Our Ref: A/85/18/RES
Your Ref:

Application for Approval of Reserved Matters Following Outline Approval

Development Approval of reserved matters for appearance, landscaping, layout & scale following outline consent A/131/16/OUT for 9 No one & a half storey houses with garaging, including 3 No. affordable housing units.

Location Land between New Place Bungalow and Arundel Road Angmering

PLANS: 1/50
FIRST FLOOR

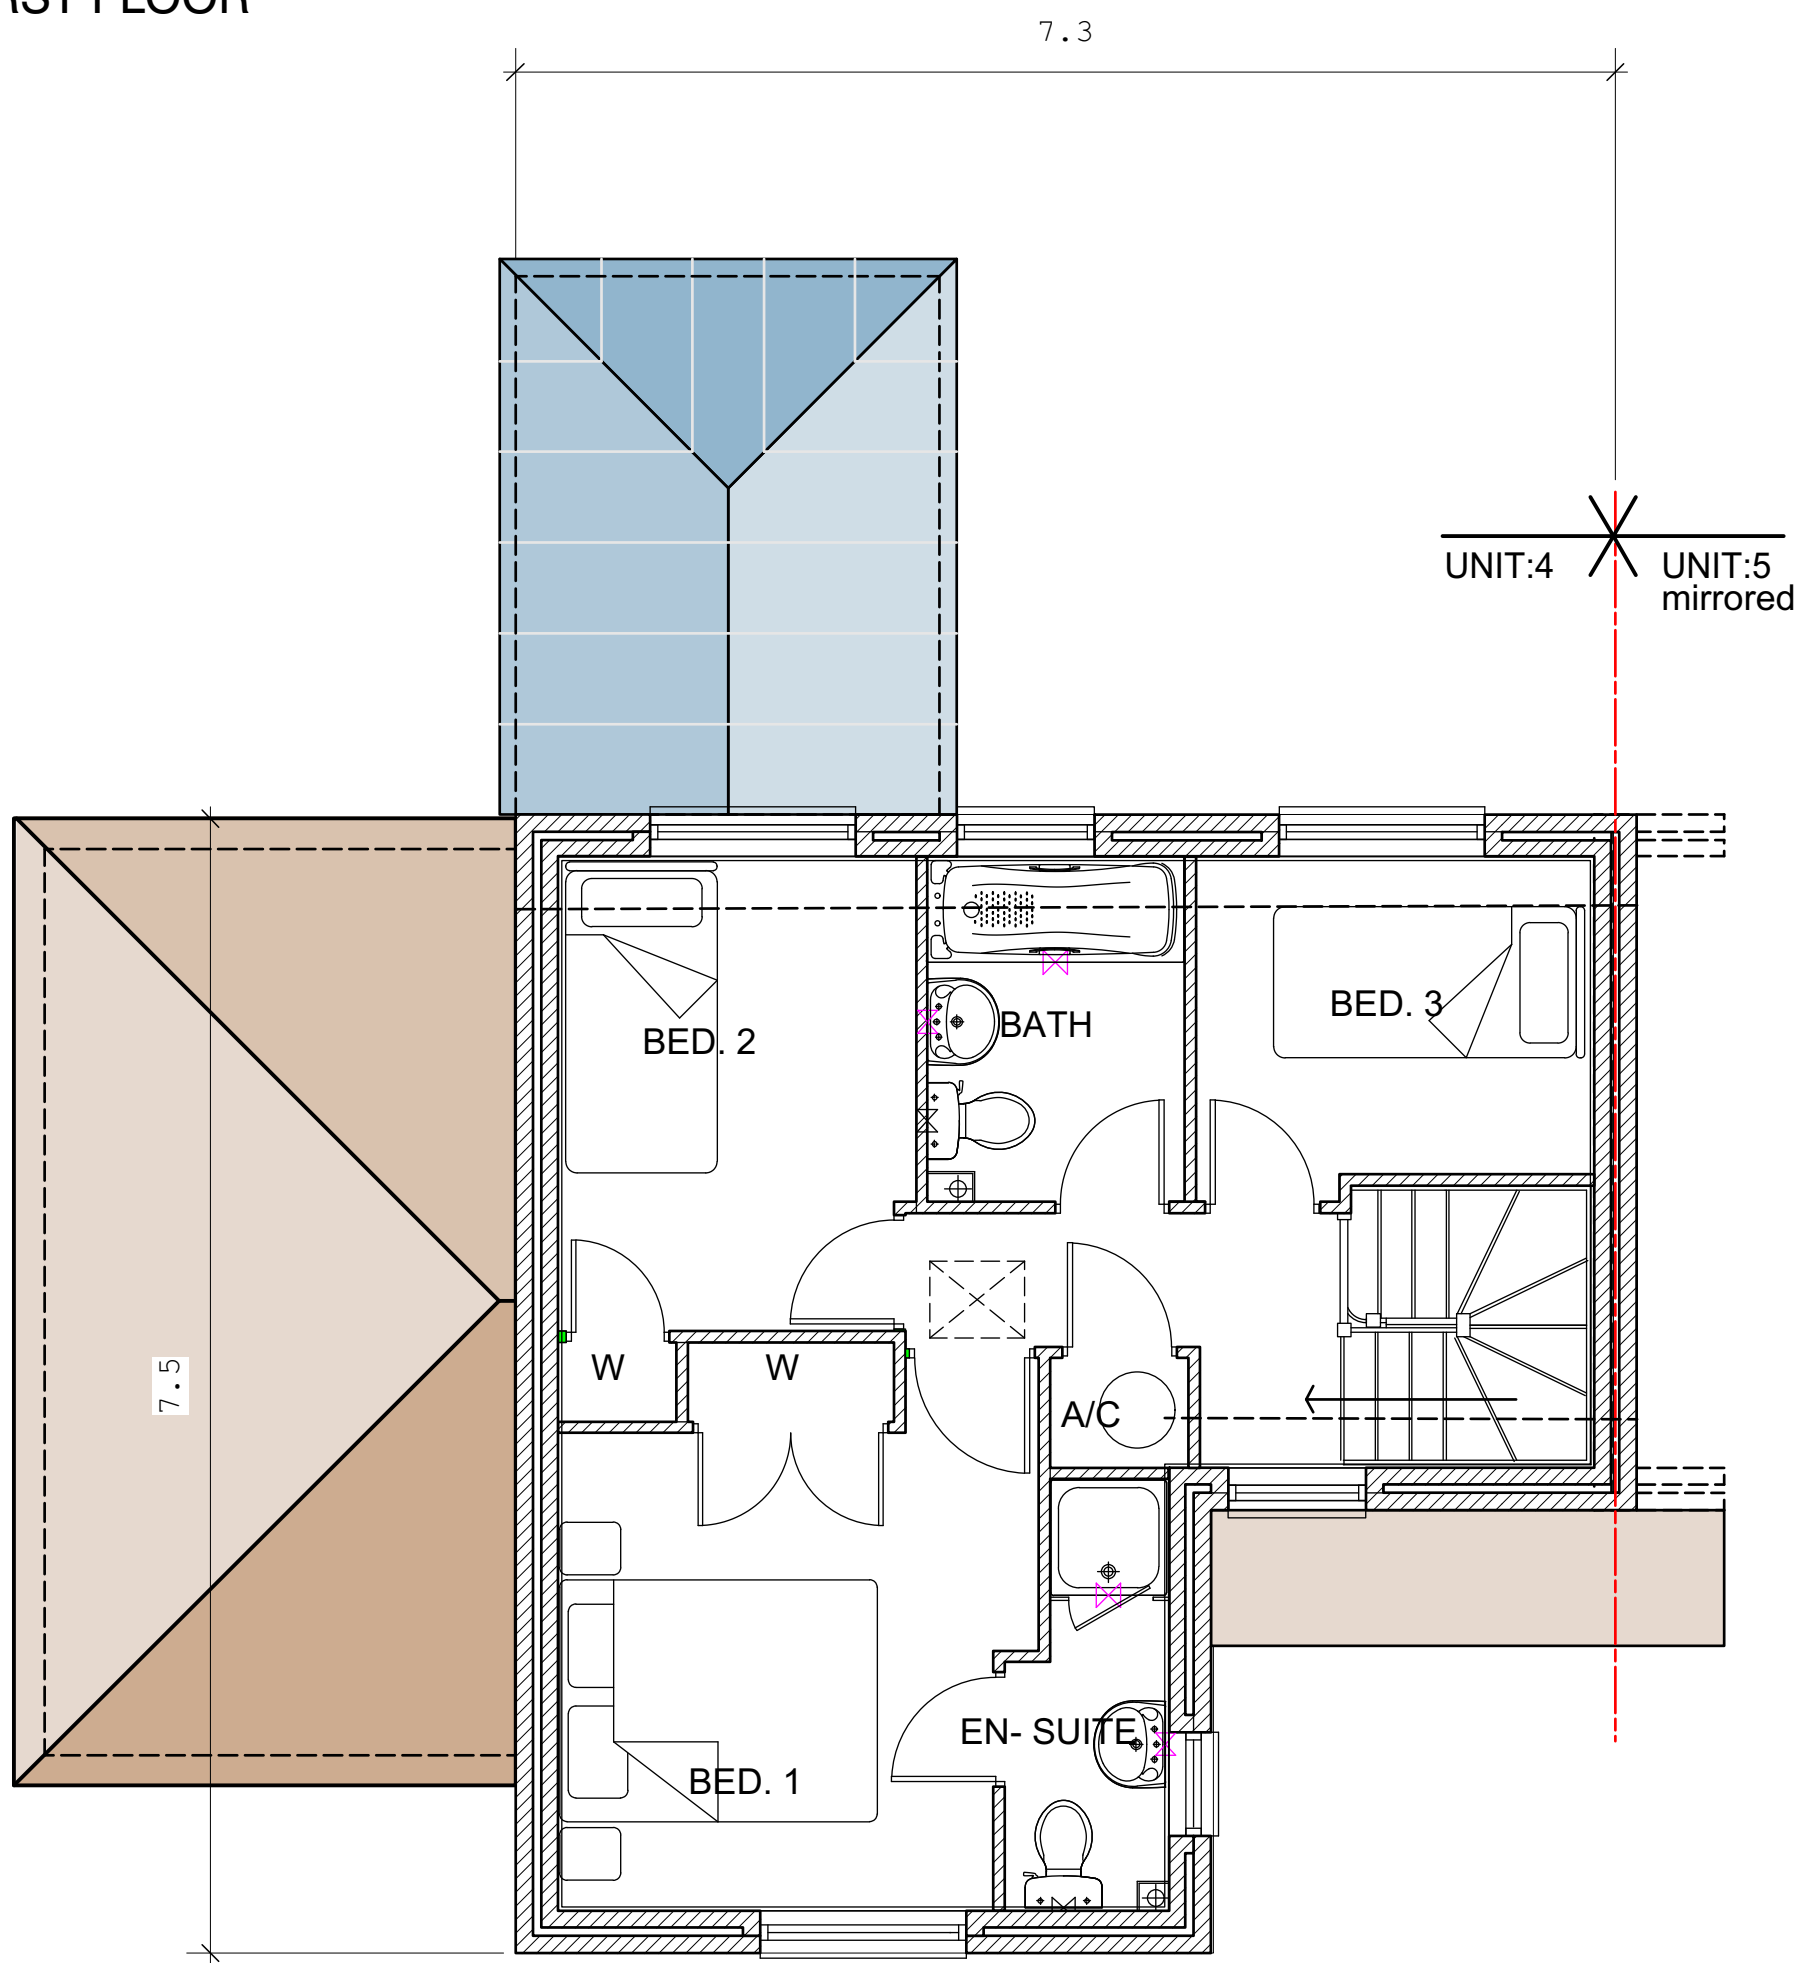
The plans, Unit B & C, rear elevation and ground floor plans do not accord. Please amend accordingly.

The plan, Unit D shows elevations for plot 4 and does not match the other plot 4, on plan Unit C. Please amend accordingly.
